A19 Downhill Lane Junction Improvement

Scheme Number: TR010024

7.23 Applicant's Response to Request for Further Information under Rule 17 of the Examination Procedure Rules

Version	Date	Status of Version
Rev 0	January 2020	Submitted for Examination Deadline 8

Drawing title: **STREETS, RIGHTS OF WAY AND ACCESS PLANS REGULATION 5(2)(k) SHEET 1 OF 2**

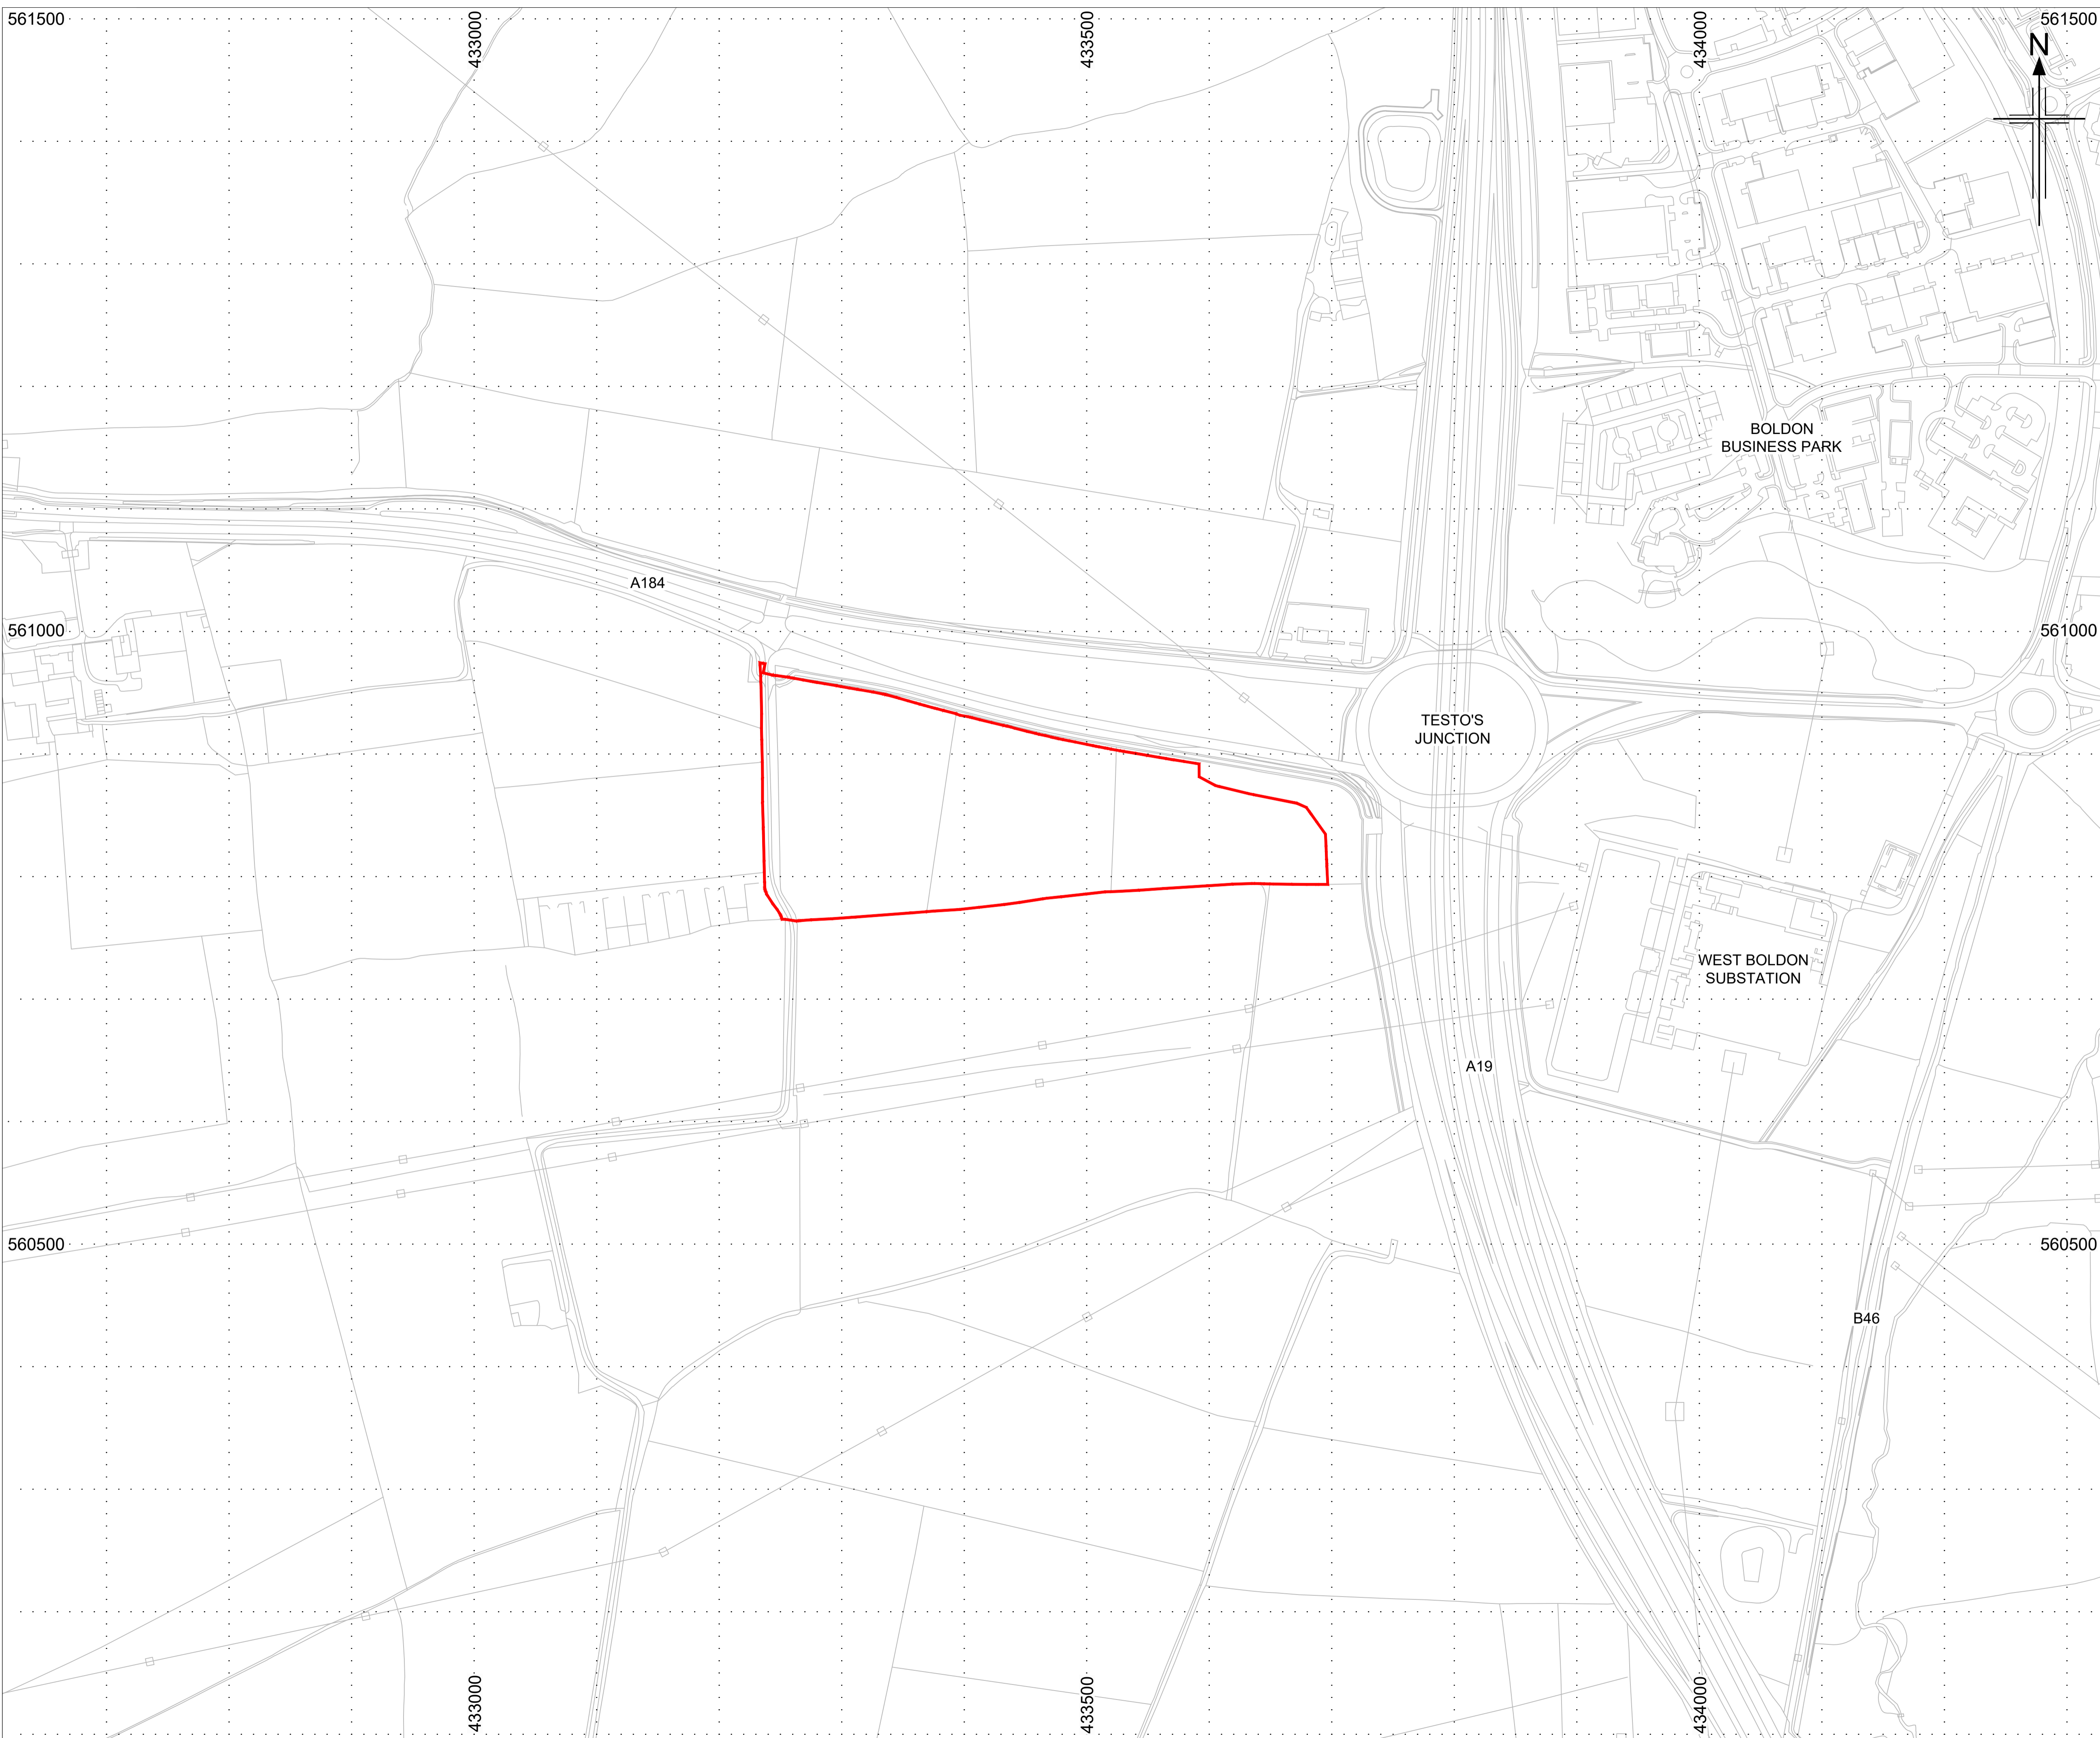
ExA's Question in Annex A of Request for Further Information dated 20.12.19	Applicant's Response dated 07.01.20
<p>On the submission Land Plans [APP-007] (Sheet 1 of 2) the notation for the area shaded blue indicated 'Rights of Way permanently extinguished or reinstated (see Note 5).' Note 5 on the LP stated 'Land over which public rights of way are proposed or proposed to be extinguished under the A19/184 Testo's Junction Alteration DCO 2018, are to be extinguished or reinstated under this Scheme. See application documents TRO10024/APP/7.5 for further details.' The reference is to Examination document [APP-054] which is the Revised Plans, Drawings and Sections for the Testo's Scheme. The D5 version [REP5-003] shows the same area shaded blue with the notation altered to read 'Land over which public rights of way are to be extinguished in order to integrate the proposals with the A19 Testo's scheme in accordance with Article 38 of the DCO'. Note 5 from the submission version has now been deleted.</p> <p>1. Clarify why it is proposed to extinguish public rights of way within the area shaded blue on the Land Plans [REP5-003] (Sheet 1 of 2) when there is an existing Bridleway – Public Right of Way (B46) running through the area and which it is proposed to retain.</p>	<p>The Applicant is not proposing to extinguish the entire length of the public right of way B46 in the blue shaded area in the Downhill Lane Junction (DLJ) Land Plans (TRO10024/APP/2.3(1), and the Applicant's proposals do not have this effect.</p> <p>In line with standard practice, the DLJ Land Plans are divided into plots which align with title boundaries, with each plot then given the appropriate shading according to the powers in the dDCO. However, the Applicant would stress that the Land Plans (and associated plot shadings) must also be read in conjunction with the latest versions of the DLJ Streets, Rights of Way and Access Plans, and the dDCO.</p> <p>The DLJ dDCO proposes only to remove Work No. 4 of the Testo's Junction Alteration Development Consent Order 2018 (the Testo's DCO), on commencement of the DLJ Scheme (as per article 36 and Schedule 8 of the DLJ dDCO submitted at Deadline 5 (TRO10024/APP/3.1(6)).</p> <p>When the Testo's DCO was being considered (2017-2018), it was not expected that Work No. 6 would be implemented independently of Work No. 4, as is now the case.</p> <p>Following the implementation of Work No. 6 of the Testo's Order, the bridleway no longer follows the former alignment of the public right of way shown as the dashed blue line between Points 1/Q and 1/N on the DLJ Streets, Rights of Way and Access Plans. Instead, the bridleway now follows the dashed brown line between Point 1/Q and 1/N on the DLJ Streets, Rights of Way and Access Plans.</p> <p>As a result of this, Schedule 8 to the DLJ dDCO amends Schedule 4 of the Testo's DCO so that the public right of way over that <i>part</i> of the B46 which is now obsolete (i.e., the dashed blue line between Point 1/Q and 1/N on the DLJ Streets, Rights of Way and Access Plans) is extinguished.</p>

ExA's Question in Annex A of Request for Further Information dated 20.12.19	Applicant's Response dated 07.01.20		
	B46 between 1//N and 1/21 in the Streets, Rights of Way and Access Plans	Existing public right of way	No change
<p>Please explain where in the dDCO the power to extinguish the Public Rights of Way over the land shaded blue on the DLJ Land Plans is contained?</p>	<p>The specific rationale for the proposed extinguishment of <i>only part</i> of the existing B46 is, therefore, effectively clearing an errant public right of way over an area in which there will be no path (the new bridleway will follow the dashed brown line). The wider rationale for the amendment of the NMU provision under the Testo's Order is contained in the Applicant's Response to the ExA's Second Written Questions, in particular the "preliminary comments" contained in the introduction to the Applicant's response to ExQ2.5.5.</p> <p>The extinguishment of public rights of way described above is legally carried out under article 13(1) of the Testo's DCO. Article 13(1) of the Testo's DCO authorises the stopping up of public rights of way in Schedule 4 to that Order. Article 36 of the DLJ DCO (and its associated Schedule 8) would amend Schedule 4 of the Testo's Order so that the extinguishment of Points 1/ P to 1/Q (shown dashed blue) would occur. To achieve this, it is also necessary to amend the Testo's Streets, Rights of Way and Access Plans, and to extend the light blue "stopping up" line on Sheet 1 of those plans so that it runs from Points 1/7 to 1/9 on those plans. Accordingly, Schedule 4 of the Testo's DCO would need to refer to "Point 1/9" in the first row of the first table (page 43 of the Testo's DCO).</p> <p>Under article 36 of the DLJ dDCO, the amendment of the Testo's DCO would only have effect once the DLJ Scheme had commenced.</p>

<p>The Applicant has acknowledged that a further part of Bridleway B46 would need to be stopped up associated with the implementation of Work No. 6 in the Testo's DCO which is currently under way. The proposed stopping up is between points 1/8 and 1/9 as shown on the Streets Rights of Way and Access Plans (revised D5 version [REP5-004]) in addition to that between points 1/7 and 1/8.</p> <p>2. Under which DCO powers is it proposed to stop-up part of Bridleway B46 between points 1/8 and 1/9 in addition to between points 1/7 and 1/8?</p>	<p>As per the Applicant's response directly above, the extinguishment of public rights of way described above is legally carried out under article 13(1) of the Testo's Order, as amended by the DLJ Scheme DCO, on commencement of the DLJ Scheme.</p>

<p>3. Does either DCO provide for the improvement of Bridleway B46 between points 1/21 and 1/7? If not, why not?</p>	<p>There is no provision for the improvement of the Bridleway B46 between Point 1/17 to Point 1/N (as shown on the DLJ Streets, Rights of Way and Access Plans) as the current provision between those points is adequate.</p>

ExA's Question in Annex A of Request for Further Information dated 20.12.19	Applicant's Response dated 07.01.20
<p>In the Applicant's response to Q2.5.5. at Deadline 5 [REP5-016] there are a number of references to works being reversed including that, as a consequence of the implementation of Work No. 6 'it is now not necessary to reverse the stopping up of Bridleway B46 between points 1/7 and 1/8'. Similarly, reference is made to extinguishing rights for example 'the part of the B46 which is proposed to be extinguished under the made Testos Order will accordingly, always need to be stopped up' and 'the extinguishment of the public right of way over the B46 proceeds as per the Testos made Order'. Reference is also made to the Testos Order containing the necessary ancillary powers to deal with 'un-doing' any partially completed element of Work No. 4.</p> <p>4. Clarity is sought about the use of 'reverse', 'extinguish' and 'un-doing'. Would the ancillary powers in the Testos Order be sufficient to ensure that the on-site conditions were returned to those which existed, prior to Work No. 4 commencing?</p>	<p>The Applicant confirms that the ancillary powers under the Testos Order (namely lettered works (d), (h) and (o) – ancillary works associated with landscaping and fencing and any other works necessary to deliver the scheme which don't lead to materially new or different environmental effects) would be sufficient for this purpose of reversing and undoing any completed part of Work No. 4.</p> <p>In the Applicant's various submissions on these matters, the terms re-instate / reversal / un-doing have been used interchangeably to mean the same thing.</p> <p>In respect of the public rights of way, no reversal of any extinguishment under the Testos Order will now be required. The Applicant had previously proposed to "re-instate" part of the B46 extinguished under the Testos Order but following the completion of Work No. 6, this is no longer required (whether or not the DLJ Scheme proceeds) – see further directly below.</p>

ExA's Question in Annex A of Request for Further Information dated 20.12.19	Applicant's Response dated 07.01.20														
	<p>The Testo's DCO, as made, already has the effect of extinguishing that part of the B46 denoted with a dashed green line between Points 1/P and 1/N on the DLJ Streets, Rights of Way and Access Plans. This is unaffected by the DLJ Scheme – see further the Applicant's response to Question 5 below.</p> <p>For completeness, the table set out below shows those parts of the B46 which are to be retained and extinguished, depending on whether or not the DLJ Scheme is authorised and commenced:</p>

<table><tr> <th data-bbox="1111 555 1413 587">Description</th> <th data-bbox="1420 555 1738 587">Absent DLJ Scheme</th> <th data-bbox="1744 555 2047 587">With DLJ Scheme</th> </tr><tr> <td data-bbox="1111 748 1413 1174">B46 between Point 1/Q and 1/P (shown dashed blue on the DLJ Streets, Rights of Way and Access Plans)</td> <td data-bbox="1420 748 1738 1174">Existing public right of way retained – Work No. 4 in the Testo's Order would be constructed and this part of the B46 (coloured purple) would serve as a connection to the Testo's NMU provision.</td> <td data-bbox="1744 748 2047 1174">As the DLJ dDCO removes Work No. 4 from the Testo's DCO, it will not be necessary to connect Work No. 4 to the existing B46. As a result, there will be no NMU provision required between Points 1/Q and 1/P. Accordingly, the existing public right of way between Points 1/Q and 1/P would be extinguished.</td> </tr><tr> <td data-bbox="1111 1179 1413 1359">B46 between 1/P and 1/N (shown dashed green in the Streets, Rights of Way and Access Plans)</td> <td data-bbox="1420 1179 1738 1359">Extinguished under the Testo's Order (as made) as the public will use the new public right of way over the dashed brown line.</td> <td data-bbox="1744 1179 2047 1359">No change</td> </tr></table>

<p>The change to the Streets Rights of Way and Access Plans is described as 'Removal of the part of the B46 which was previously proposed to be reinstated. This is now shown as extinguished under the Testos Order (as originally anticipated under that Order).'</p> <p>5. The Applicant is asked to clarify the comment above.</p>	<p>The Testos DCO as originally made extinguishes the public right of way between Points 1/N and 1/P shown dashed green on the DLJ Streets, Rights of Way and Access Plans (the Green Line).</p> <p>The Applicant had, as part of the DLJ Scheme, <i>initially</i> proposed to remove Work No. 6 of the Testos DCO. As a result of the removal of this work, the public right of way over the Green Line would have to be re-instated / reversed / undone (as above, these terms are used interchangeably to mean the same thing). Absent the "re-instatement" there would be no designated public right of way over the Green Line, which would be required in circumstances Work No. 6 is not constructed.</p> <p>Following the implementation of Work No. 6 of the Testos DCO, the Applicant no longer proposes to remove Work No. 6 from the Testos DCO. Accordingly, the need to reinstate the public right of way over the Green Line also falls away. An NMU user would use the new part of the bridleway (the brown dashed line on the DLJ Streets, Rights of Way and Access Plans), and then go onto the existing public right of way over the bridleway.</p>
